Recommendation Report for Planning Permission for Works or Extension to a Dwelling

REF NO: LU/115/15/HH

LOCATION: 21 Davits Drive
Littlehampton

PROPOSAL: Single storey rear extension & new window to existing side elevation. This application may be determined by Littlehampton Town Council under delegated powers.

FRONT
PROPOSED ELEVATIONS
Scale 1:100

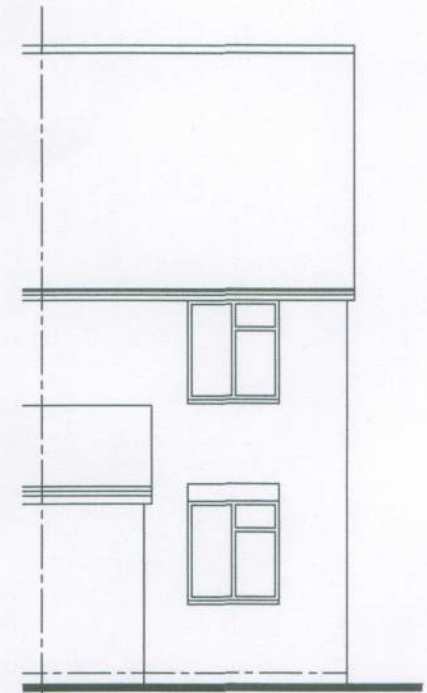
The proposed window to the side elevation is in addition to two other openings on this elevation and is replicated on the side elevation of the adjoining property. It is therefore considered to be in keeping with the existing facade of the property and the rest of the street scene.

It is proposed to impose a condition for obscure glazing and top fan opening only on the proposed window to the existing side elevation of the property so as to preclude any overlooking into the property to the south.

- 4 The proposed window shall all times, except for the top light, be fixed shut and remain glazed entirely with obscure glass.

PROPOSED GROUND FLOOR
Scale 1:50

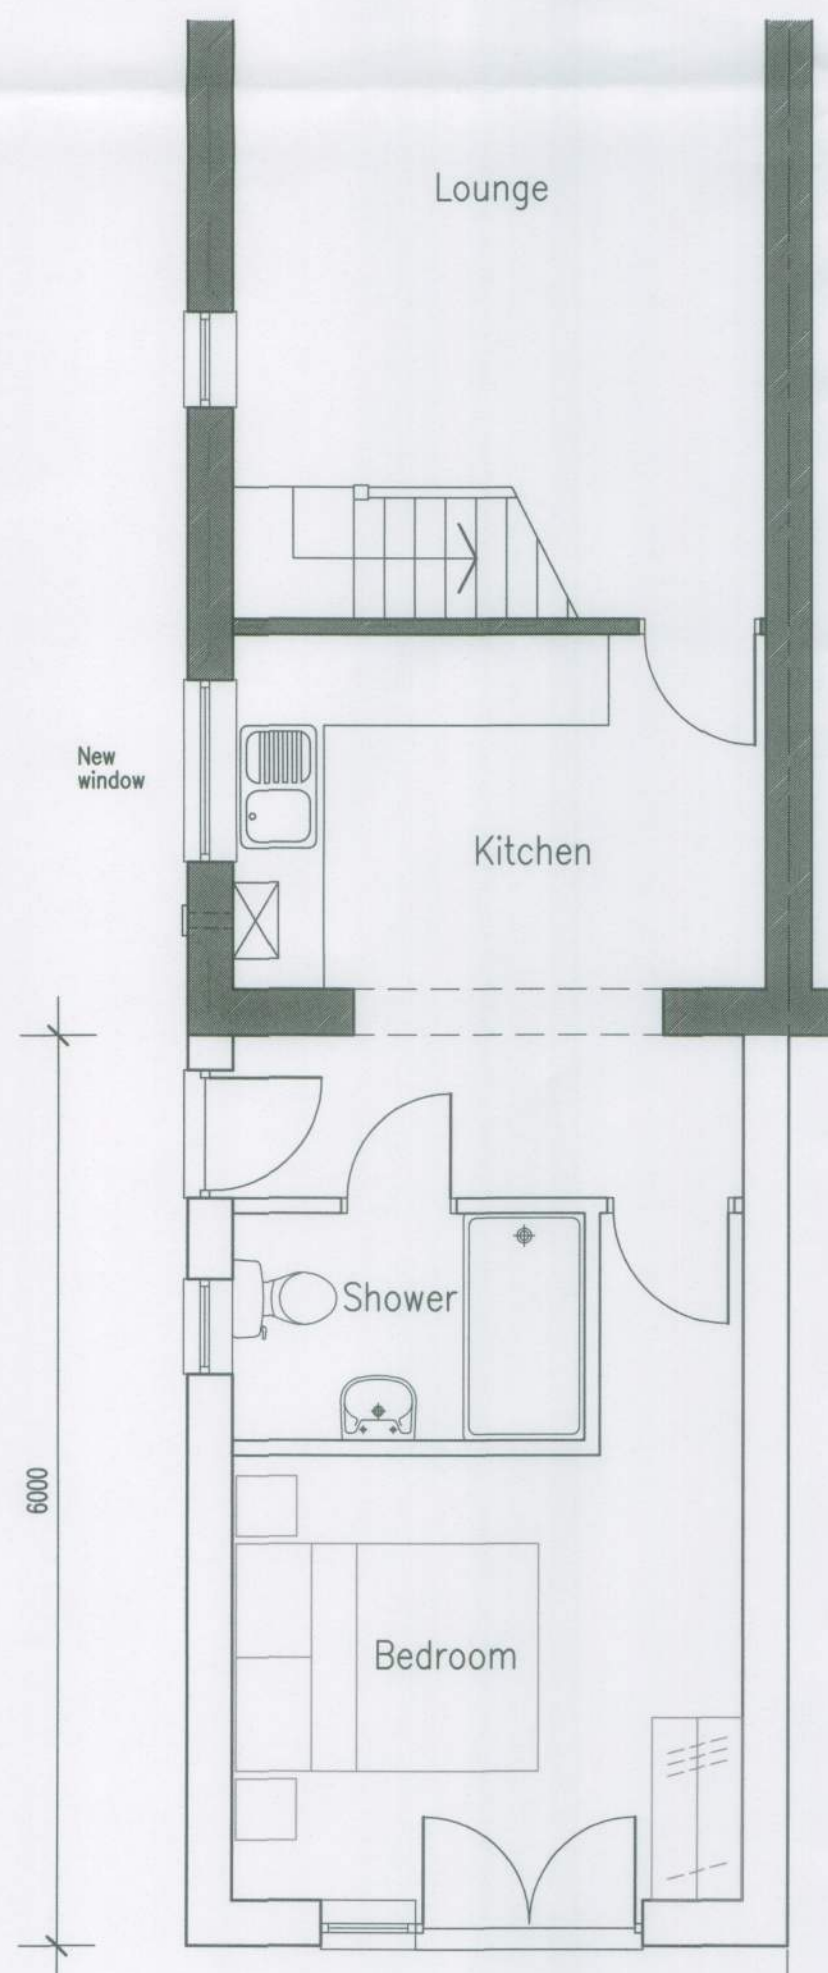
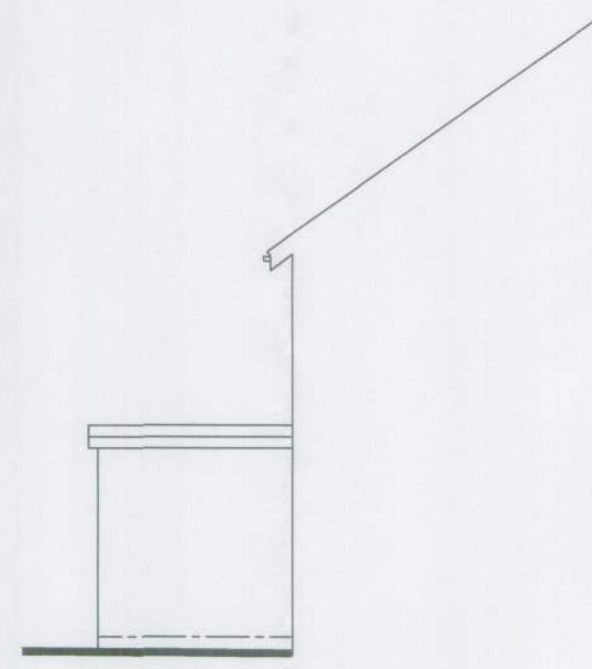
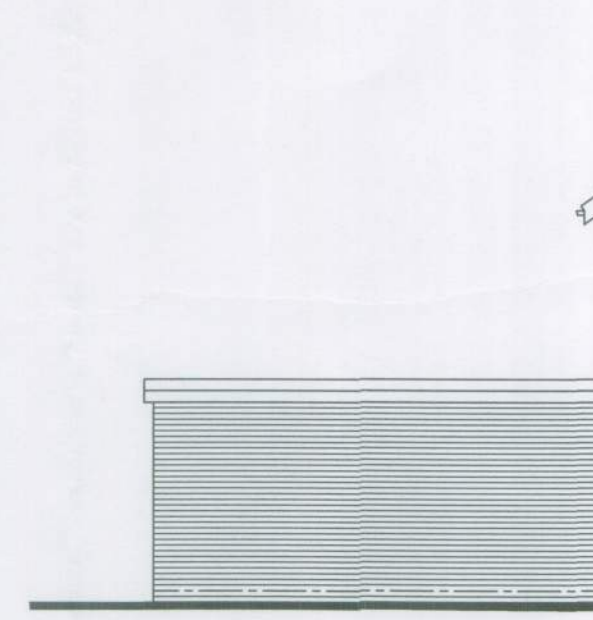
The proposal is to extend an existing flat roofed rear extension by a further 3.5 metres and maintain its existing 3m height continuing the flat roof design.

There is a similar designed rear extension on the neighbouring property. The proposed extension in this case is therefore deemed to have been designed sympathetically and visually integrated with the existing building in terms of siting, design, form and scale as well as in keeping with the existing character of the area. As such, the proposal is considered to be in accordance with policies GEN7 (ii) and DEV19 (i), (ii) & (iv) of the Arun District Local Plan.

To the south the rear extension will be set away from the neighbouring boundary by 3m which will mean that there will be no adverse impact on residential amenity on that property.

To the north the extension will run alongside the neighbouring boundary where there is a similarly designed rear extension. The Council operates the 45 degree rule to ensure there is no unacceptable adverse loss of daylight on neighbouring properties. In this case the policy will be breached but given the level of boundary screening (2m high wooden fence) and additional hedge screening the additional impact on residential amenity will be acceptable.
